Stage 1 Road Safety Audit & Quality Audit including Walking and Cycle Audits

**Hodson Bay,
Waterfront Project**

***Hodson Bay, Barrymore,
Co. Roscommon***

31022-CIV-XX-XX-S-C-00100-Hodson Bay_General Arrangement

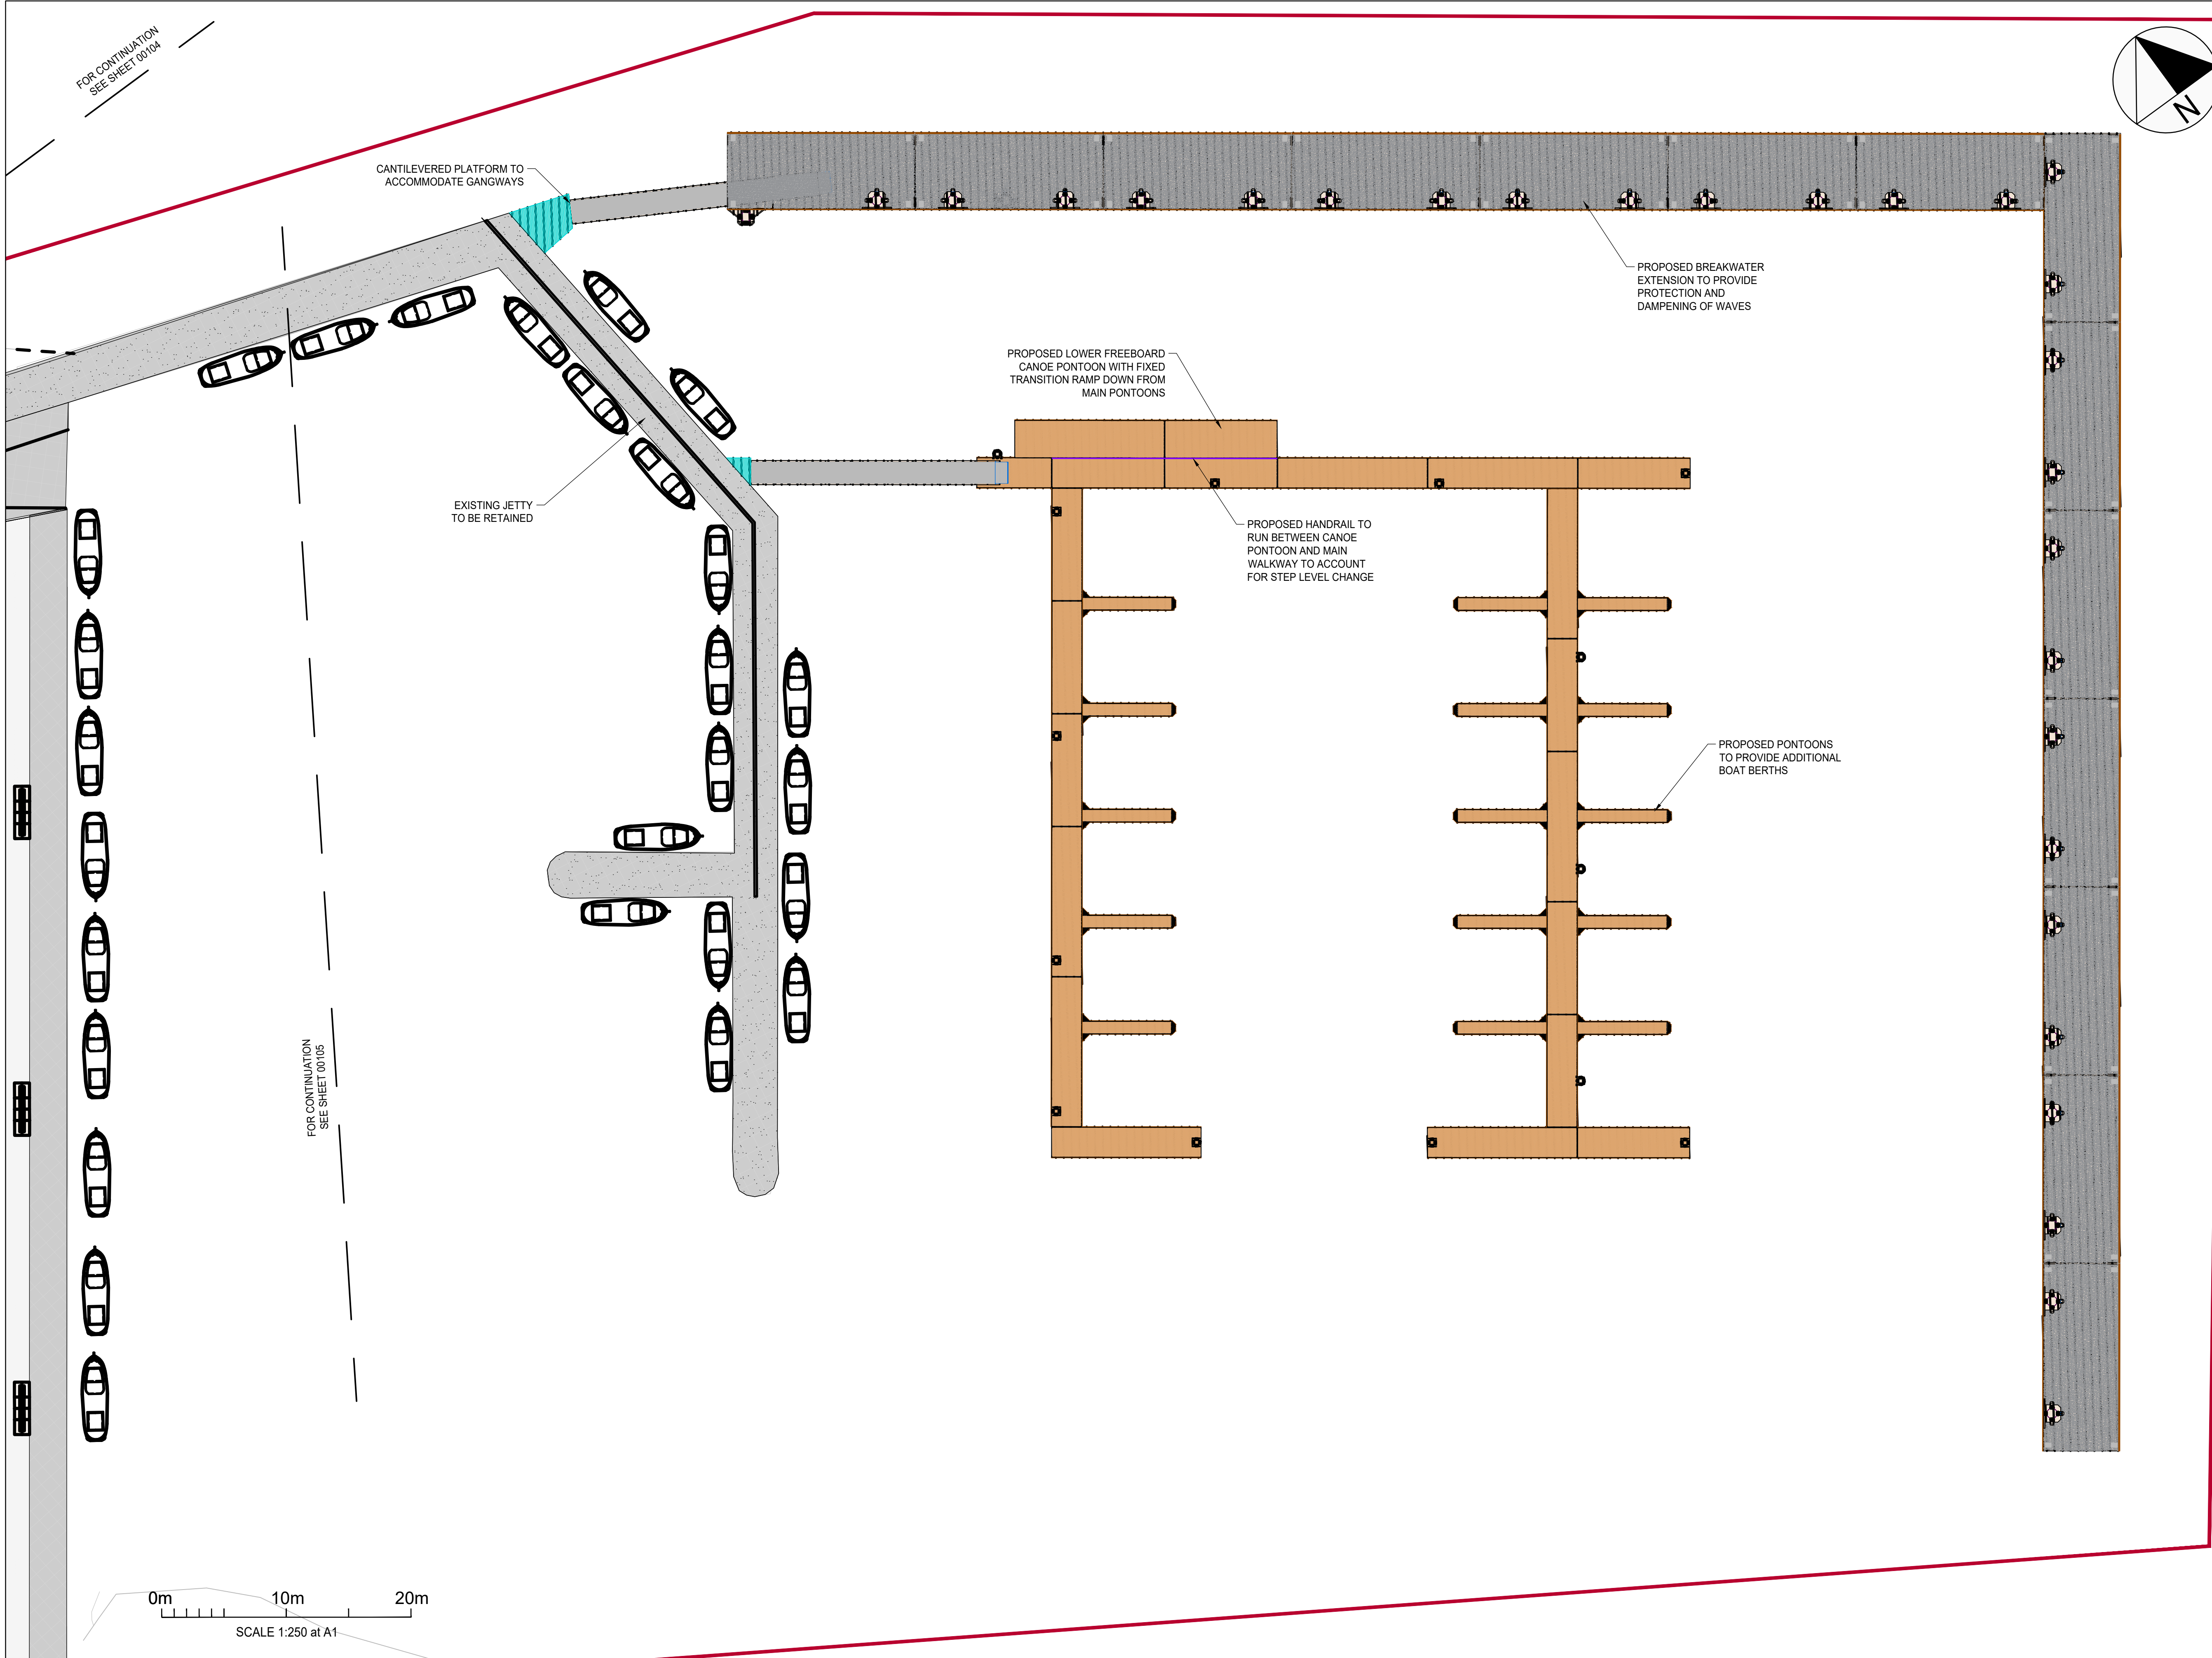
The proposed development includes a number of EV charging spaces; however, the associated charging equipment appears to be located within the pedestrian footway. EV charging units are often substantial in size, and charging cables may extend across pedestrian routes during use. This could obstruct the footway and increase the risk of trips and falls, particularly for visually impaired pedestrians and wheelchair users.

The EV charging equipment should be located outside the pedestrian desire line, with dedicated space provided adjacent to the parking bays to ensure the footway remains clear and unobstructed. The layout should be designed to minimise the potential for charging cables to encroach onto pedestrian routes during operation.

3.10	Yes	Yes		
4.1	Yes	Yes		
4.2	Yes	Yes

SITE LAYOUT PLAN
SWEPT PATH ANALYSIS - BUS
SHEET 6 OF 9

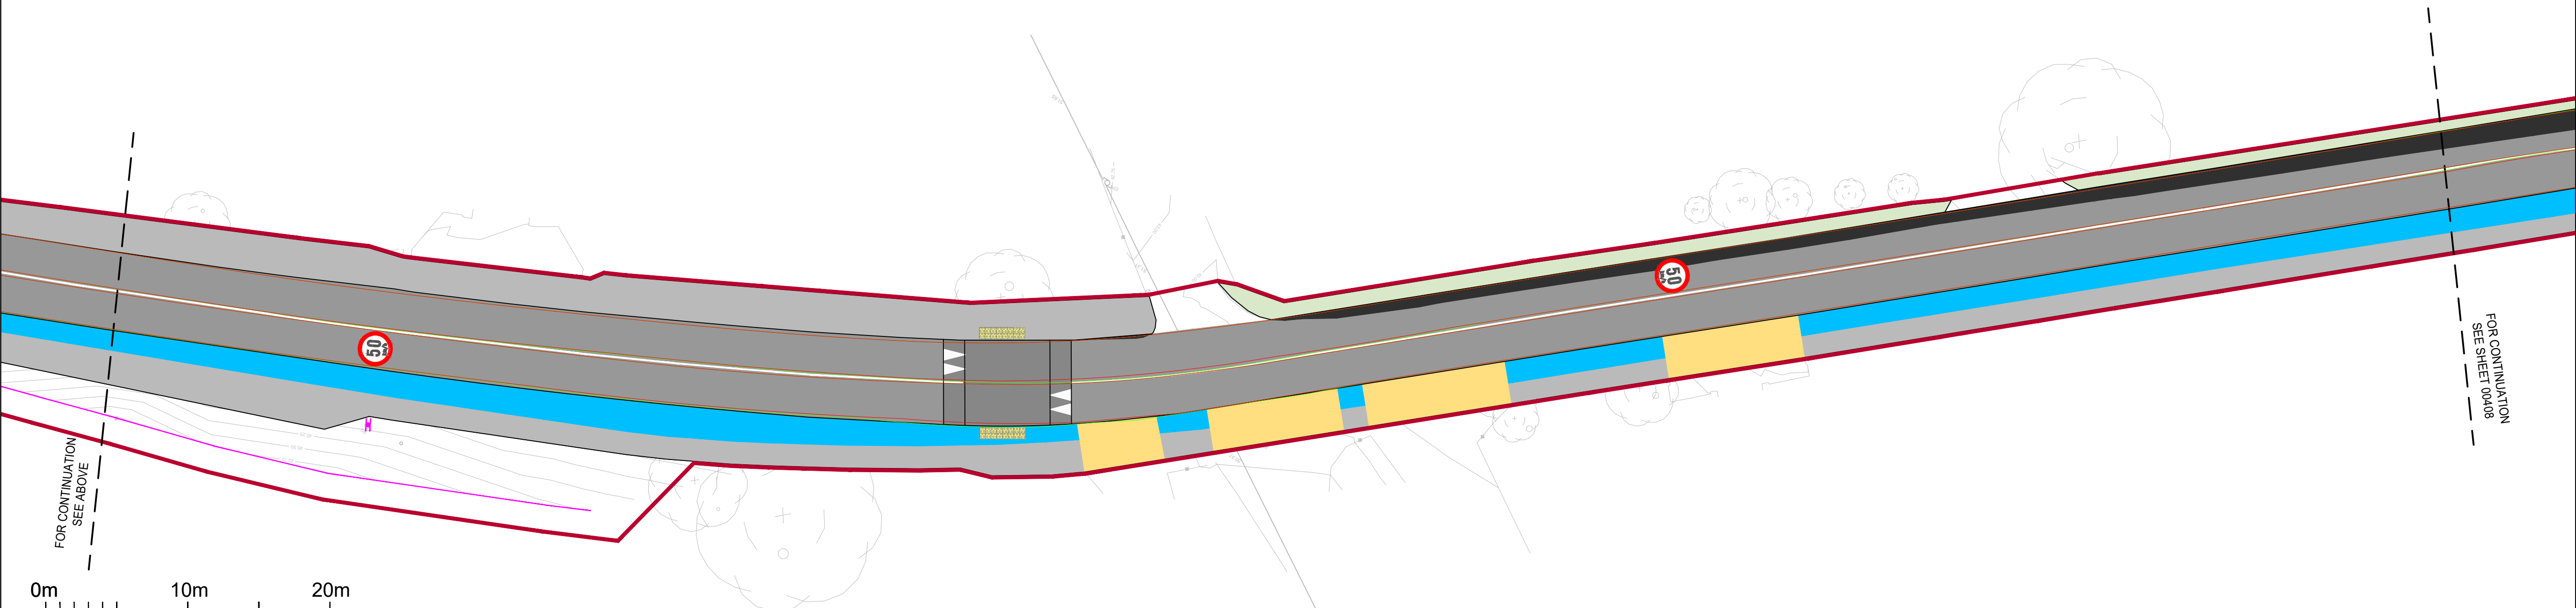
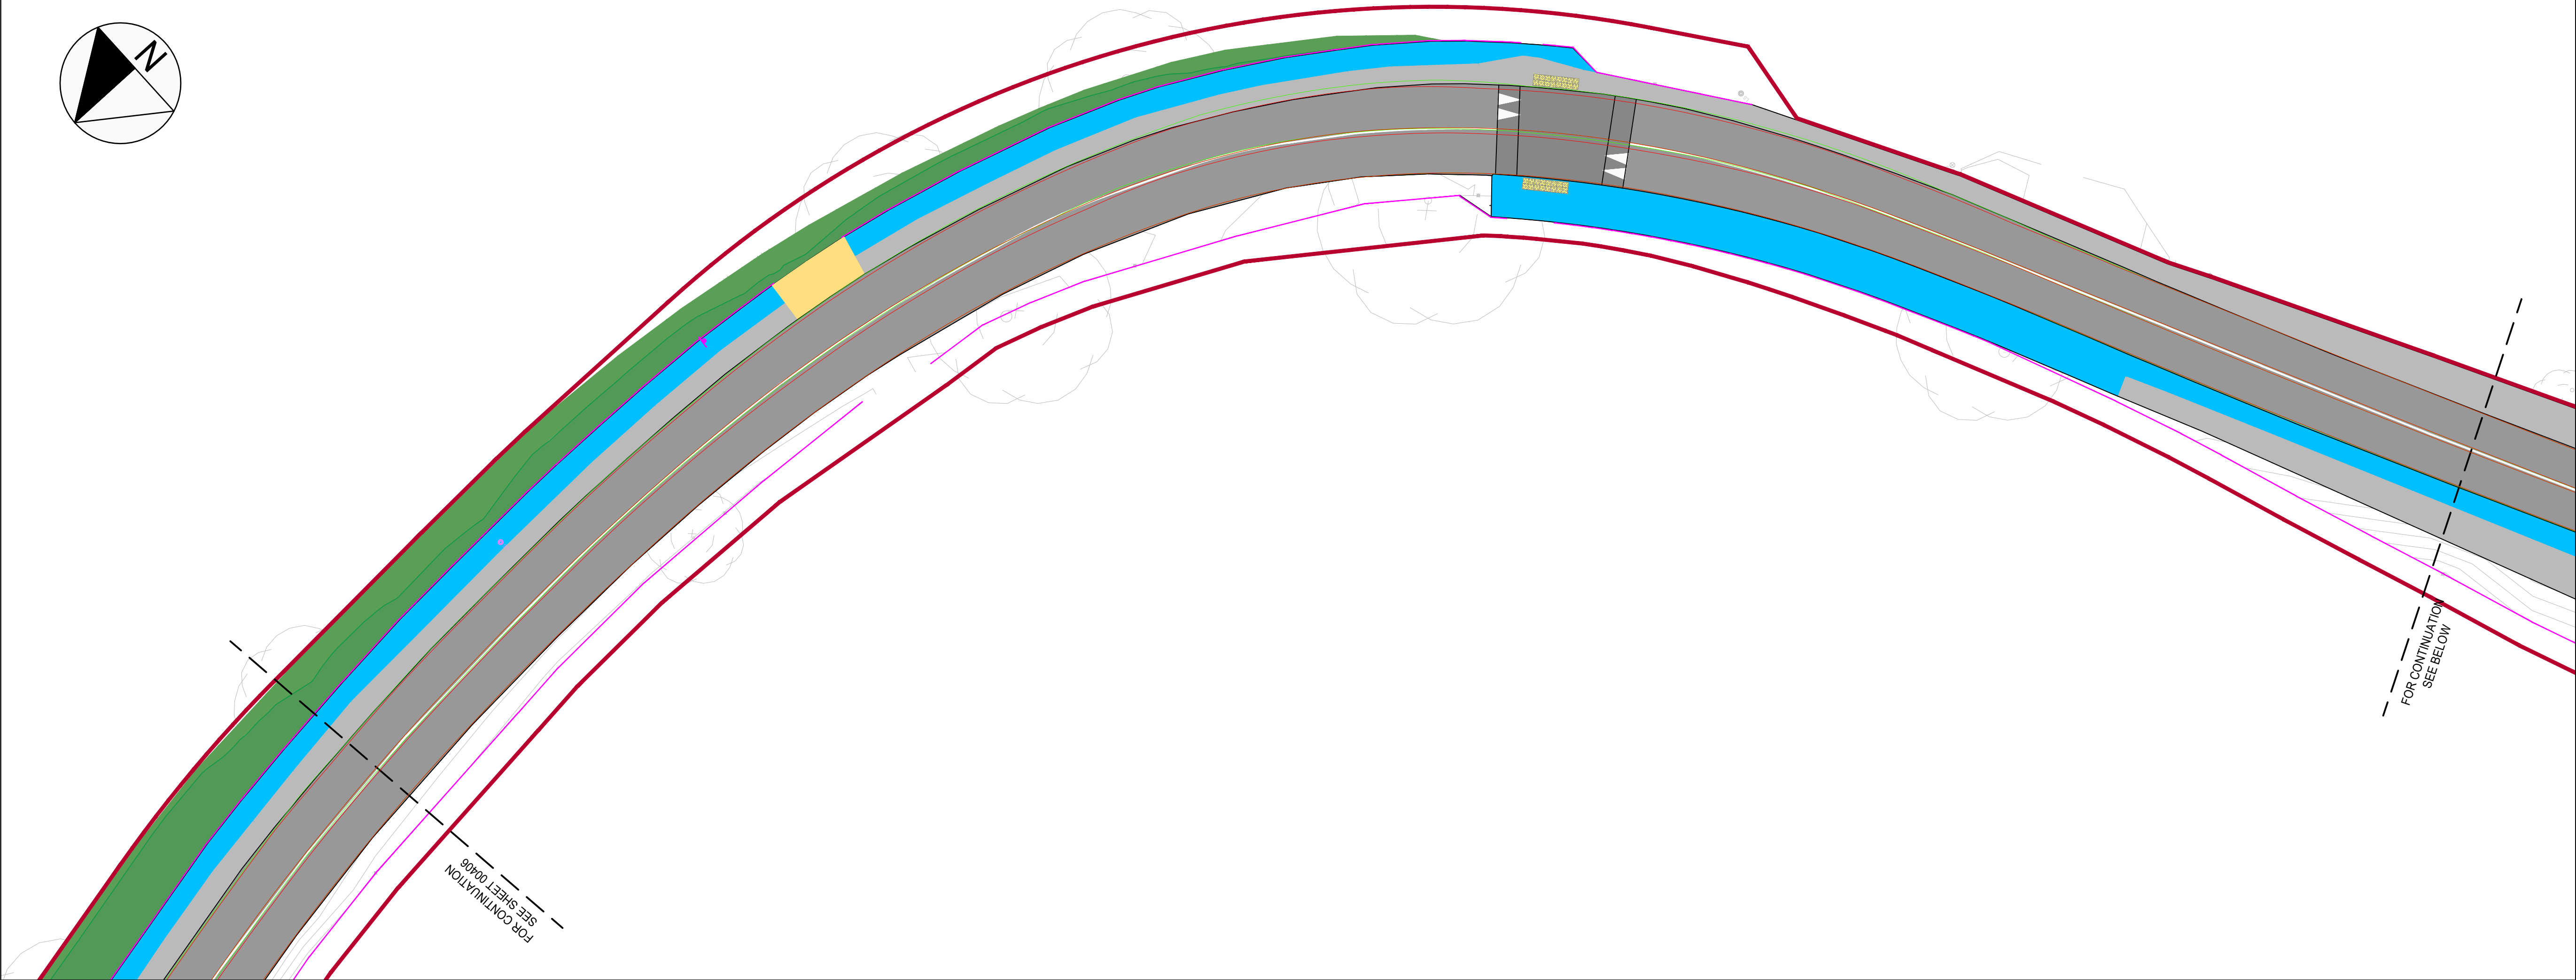
While the proposed narrowing of the carriageway is expected to reduce vehicle speeds, larger vehicles, particularly buses, may overrun the centreline on tight bends due to their swept path and rear overhang. This could result in opposing vehicles being forced to take evasive action or lead to side-swipe or head-on collisions.

The carriageway widths should be reviewed, in particular at tight bends using swept path analysis. Where necessary, the road carriageway should be widened locally to accommodate the largest anticipated vehicle, while maintaining the traffic calming objectives of the scheme.

3.1	Yes	No	The proposed narrowing forms an integral part of the traffic calming strategy and is intended to reduce vehicle speeds within the scheme area. Vehicle tracking has been undertaken to confirm that two 15 m coaches can safely pass at all proposed carriageway narrowing locations. The existing sections of the L2020 that are outside the scope of the proposed works and are not being altered and will remain unchanged. Accordingly, the proposed layout is considered capable of accommodating the anticipated vehicle movements while maintaining the objectives of the scheme.	Yes

RAISED SPEED TABLE
(Scale 1:50)

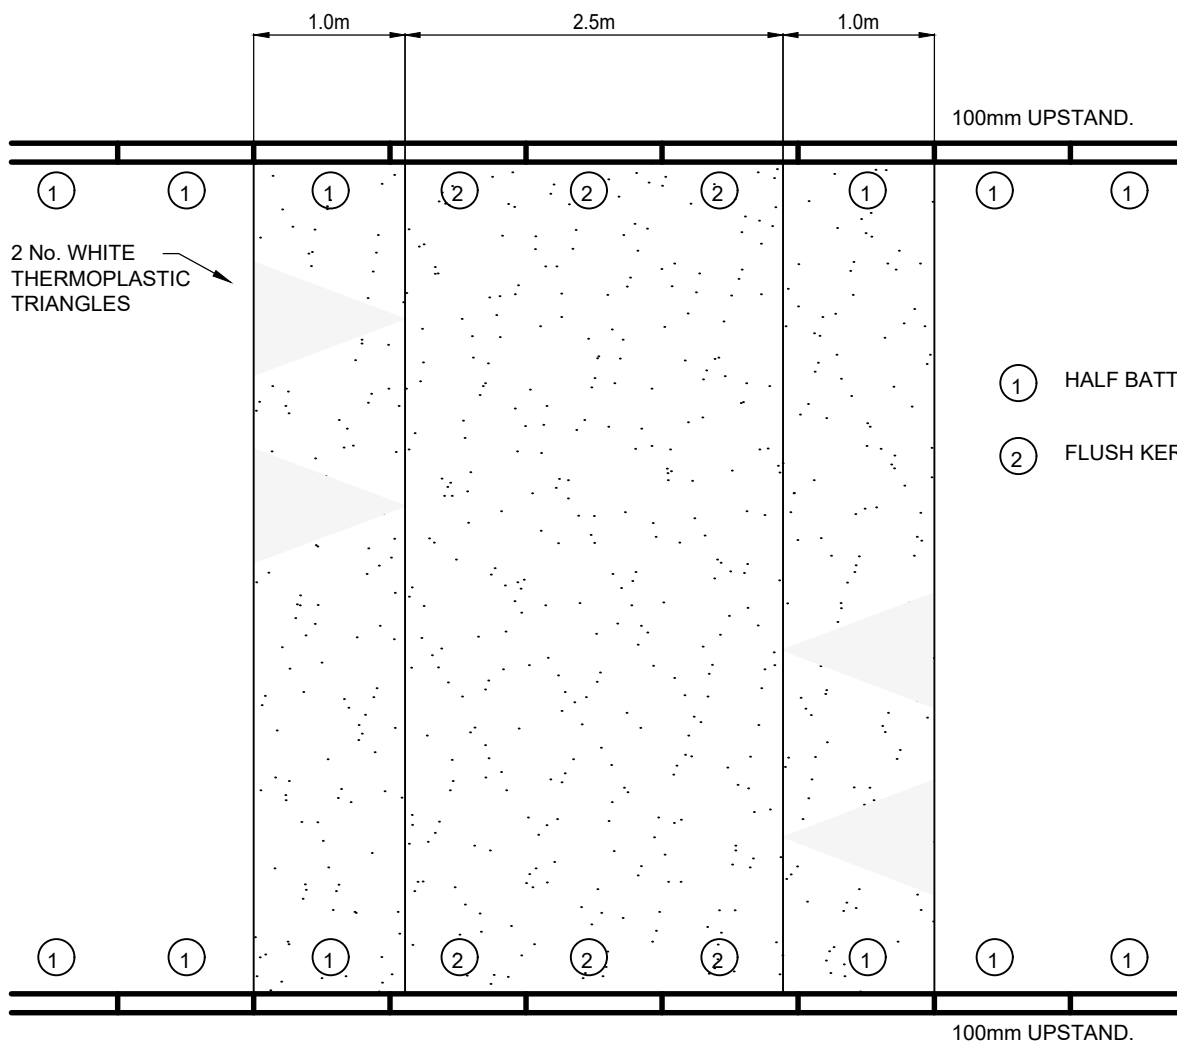
A significant number of buses were observed using the site. The proposed raised pedestrian crossings appear to incorporate relatively short flat-top tables. This may result in buses experiencing excessive vertical deflection when traversing the crossings, leading to discomfort for passengers and potentially encouraging drivers to brake sharply before, and accelerate after the crossings.

The raised pedestrian crossings should incorporate a minimum 6.0 m flat-top table to provide a smoother transition for buses while maintaining effective speed reduction and pedestrian priority.
